**MARSHALL ENGINEERING SERVICES, PLLC**  
7575 McCartans Ford  
Linden, NC 28356  
(910) 850 5874  
Corp. Licenses P-0682  
[Randolph@RandolphMarshall.com](mailto:Randolph@RandolphMarshall.com)

Bernard Restifo  
2236 Josie Williams Road  
Erwin, NC 28339

March 27, 2019

I inspected the concrete slab on grade foundation for a metal building at the above address.

**CONCRETE BASE RAIL ANCHORAGE**

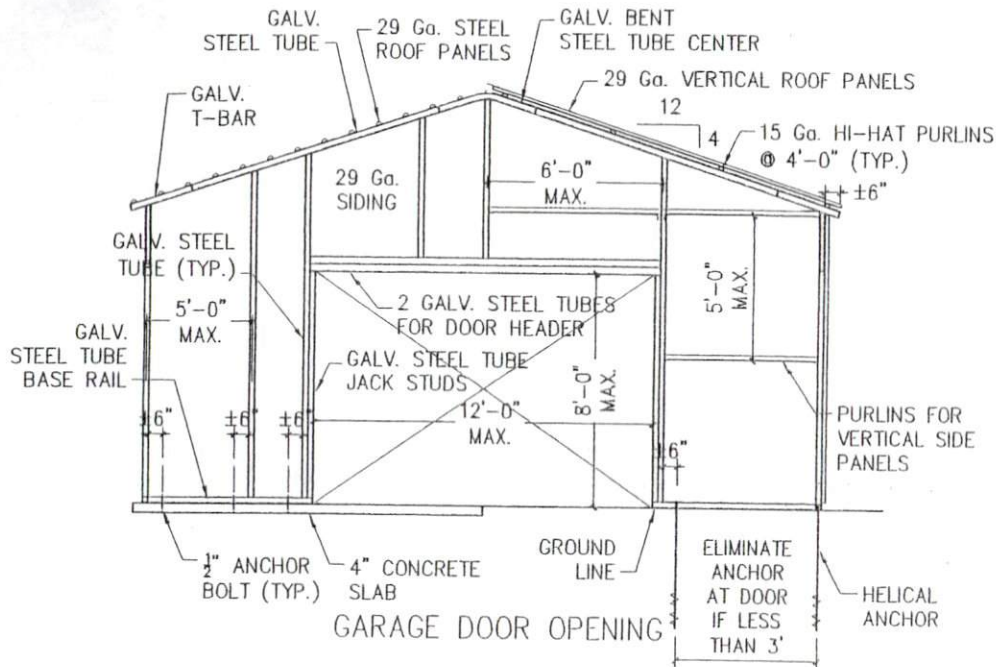
The construction drawings require a 4-inch slab on grade with the building steel bolted to the concrete. The design requires a minimum concrete compressive strength at 28 days of 2500 psi.

I inspected the concrete slab. Four inspection holes were excavated around the building perimeter. The slab is 4-inches thick. The perimeter steel is bolted the slab as shown on the design drawings. The concrete tickets indicate the mix was a 3000-psi design which exceeds the design requirements.

This foundation complies with the design drawings. I have no structural issues with the foundation system.
